**KIRKLEES METROPOLITAN COUNCIL
INVESTMENT & REGENERATION SERVICE**

DELEGATED DECISION TO DETERMINE PLANNING APPLICATIONS

Reference No:	2023/62/92054/E
Site Address:	Church Field Farm, Church Lane, Hartshead, Liversedge, WF15 8ET
Description:	Erection of detached open garage
Recommending Officer:	Nicole Helliwell

Officer Report

Proposed Site Plan

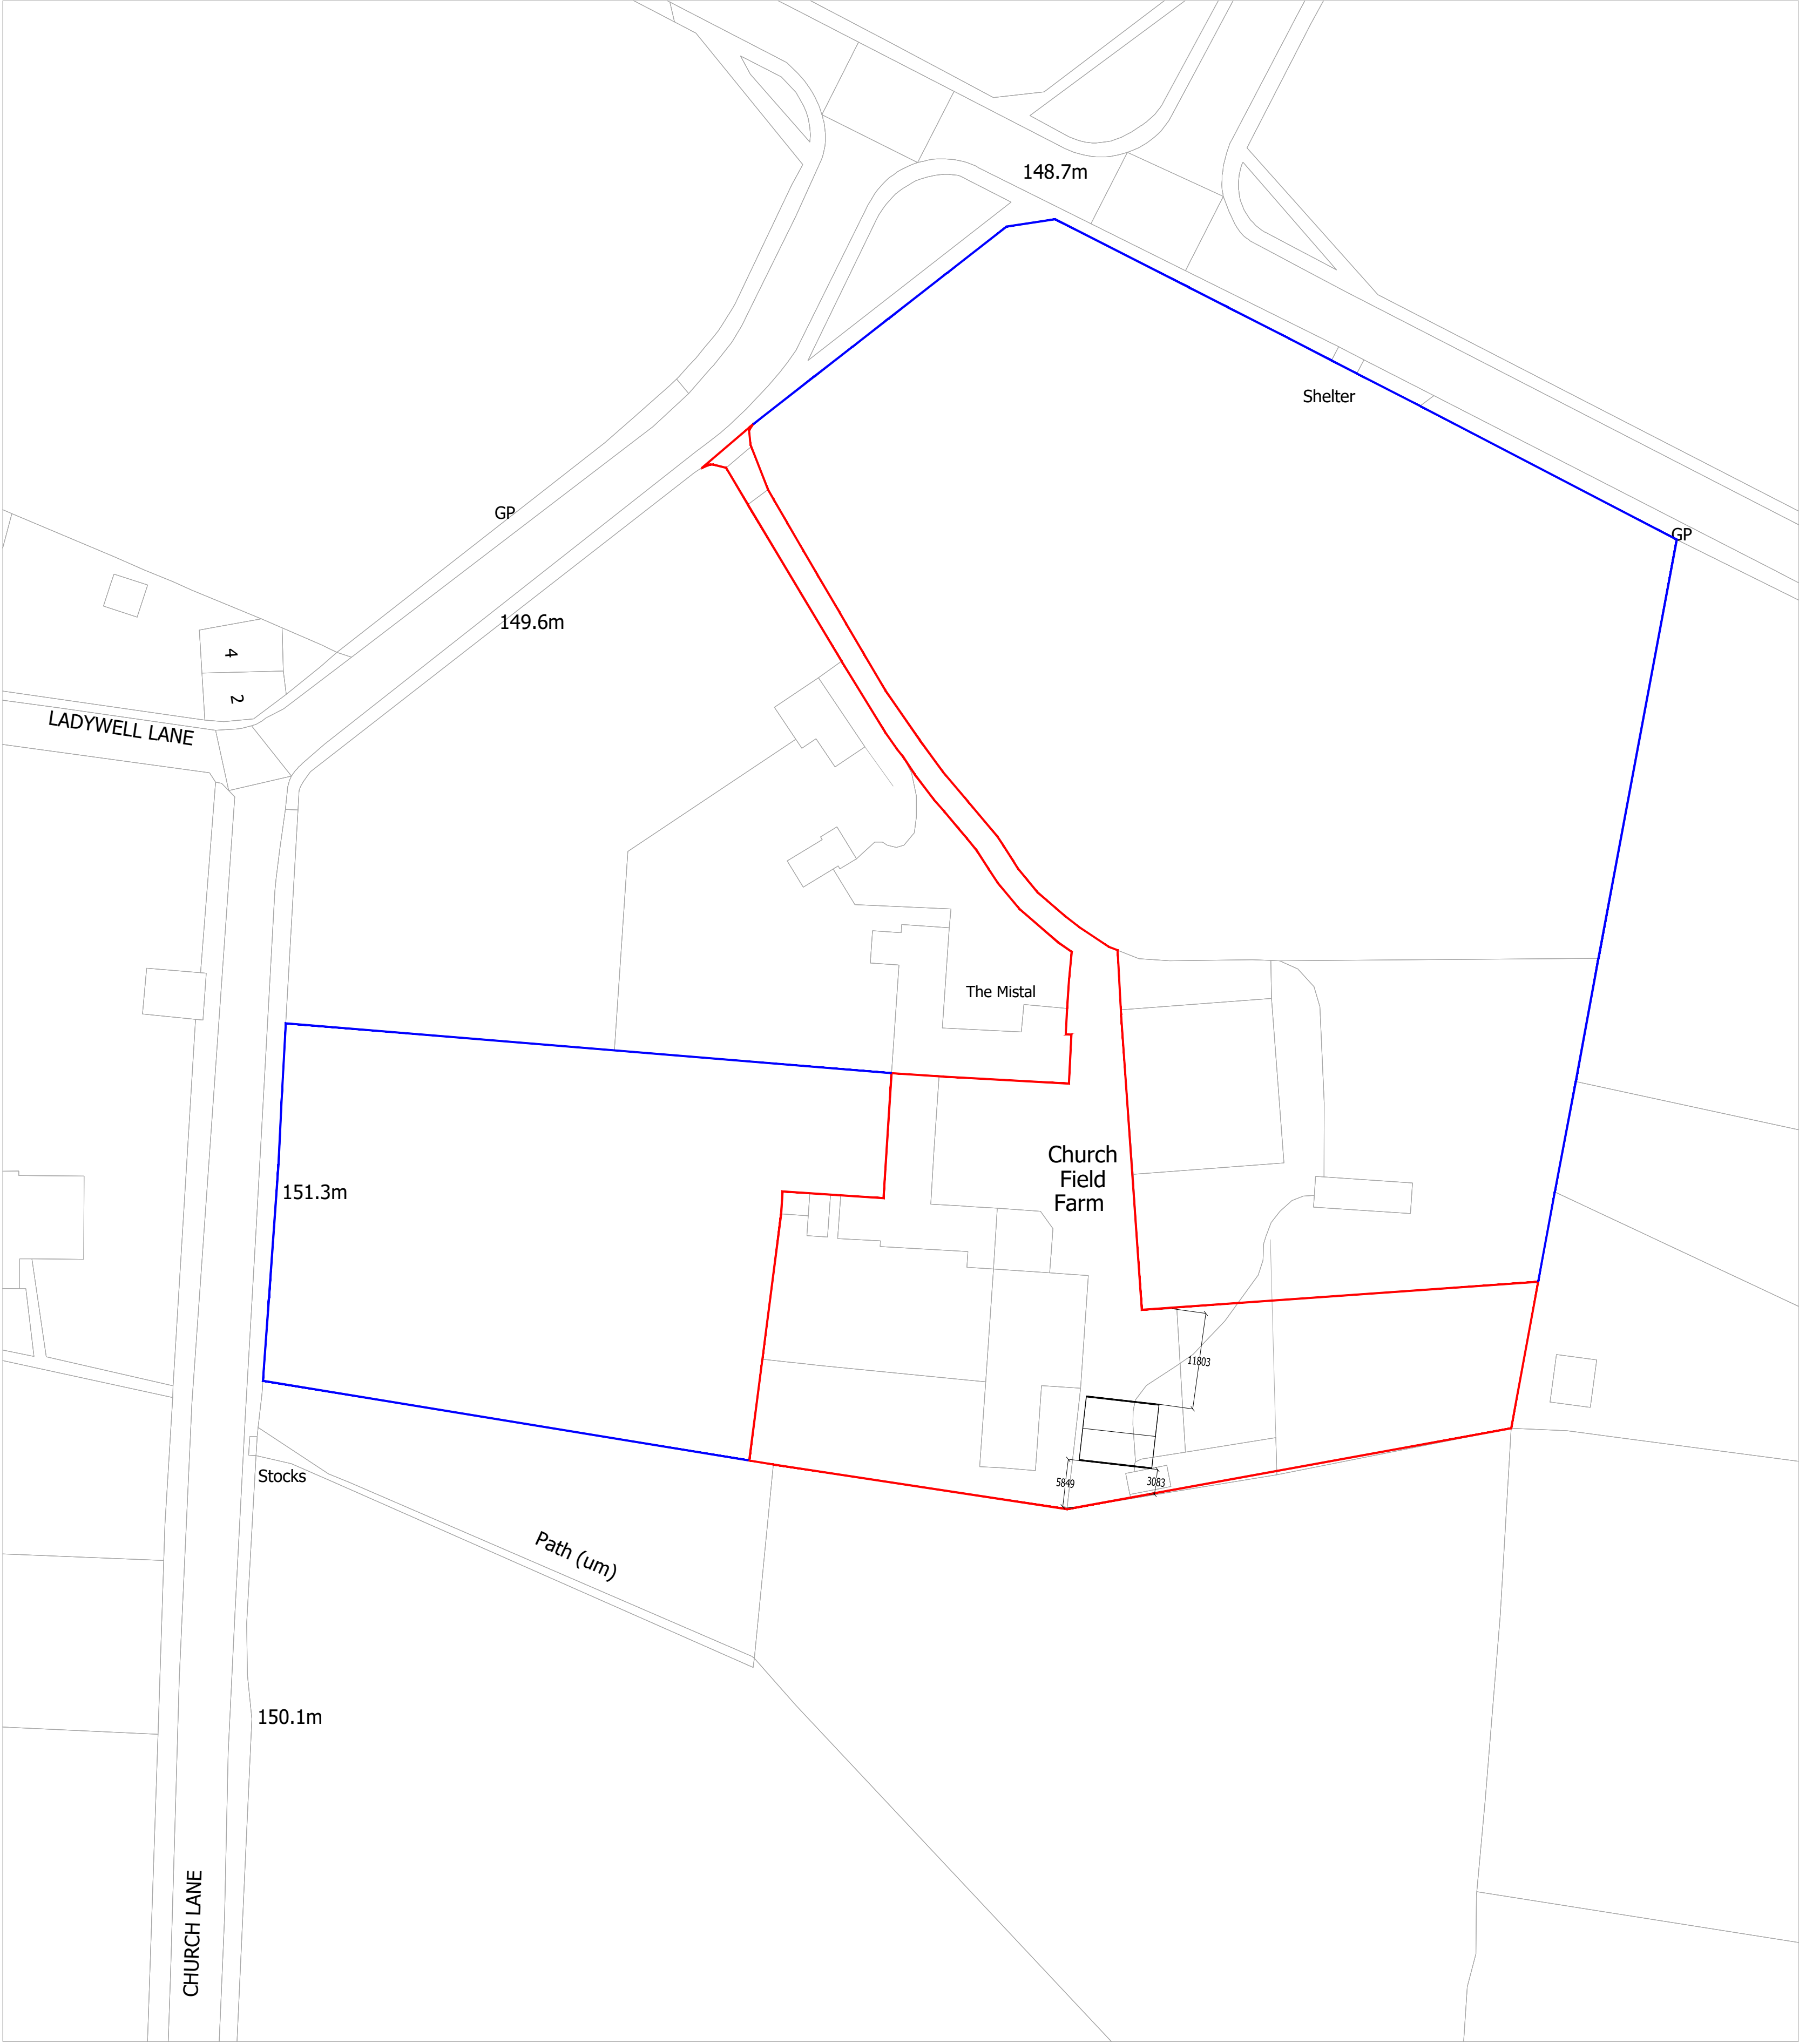
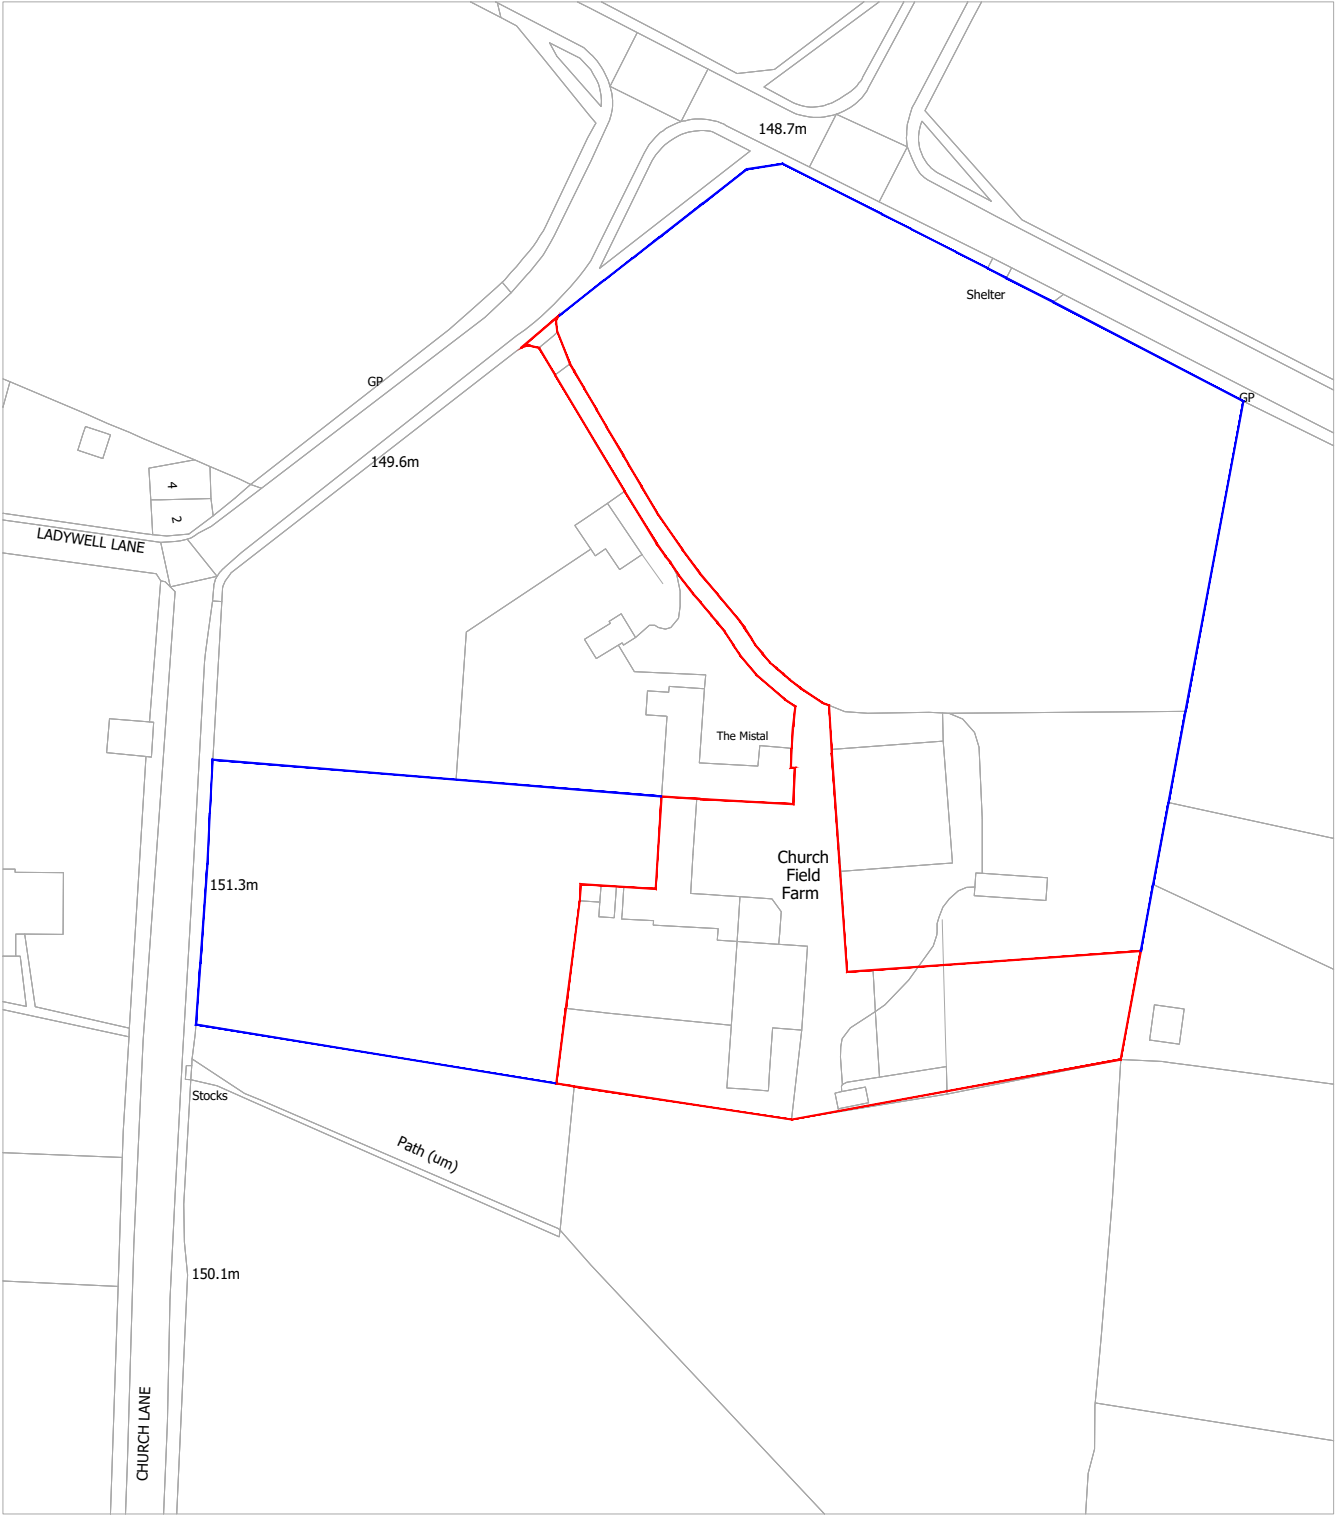
The proposed detached garage cumulatively with the existing additions would result in an increase of approximately 92.8% in the overall floor space of the dwelling which would result in disproportionate additions over and above the size of the original building. It is therefore considered that the impact of the proposals on the openness of the Green Belt, both spatially and visually, would be unacceptable. As such, the proposal would fail to accord with Policy LP57 of the Kirklees Local Plan and the guidance contained within Chapter 13 of the NPPF.

In addition to the above, as an aside, it is noted that the proposal would be located on the site of an existing timber outbuilding which presumably would be removed to make way for the proposal. Whilst this does not appear to have the benefit of planning permission, aerial images indicate that it has been in situ since at least 2018 and is therefore likely to be lawful due to the passage of time. Whilst the proposed garage could potentially be considered as a replacement building in this context, it would be materially larger than the one it is to replace and have a greater impact on openness in any case and therefore would be contrary to Policy LP59 of the KLP.

Church field View is a residential property located north of the application site. It is noted that the proposed garage would occupy a position approximately 25m from the rear elevation of Churchfield View. Therefore, given that a sufficient separation distance would be retained, it is considered that the proposed development would have an acceptable impact on the neighbour's residential amenity.

Public Right of Way SPE/153/20 is located south of the application site. Given the distance retained between the proposed development and the footpath, it is considered that the proposal would not have a significant impact on the amenity of the footpath or its users. As such, the proposal was not advertised as affecting a Public Right of Way in this instance as is considered to accord with Policy LP23 of the Kirklees Local Plan.

1. The application site is located within the designated Green Belt, as set out in the National Planning Policy Framework, most development, subject to certain exceptions, is regarded as inappropriate. The cumulative impact of the proposed detached garage when considered in conjunction with previous additions, would result in disproportionate additions over and above the size of the original building. The proposal would represent inappropriate development, which is harmful to the Green Belt. No very special circumstances that clearly outweigh the harm to the Green Belt have been
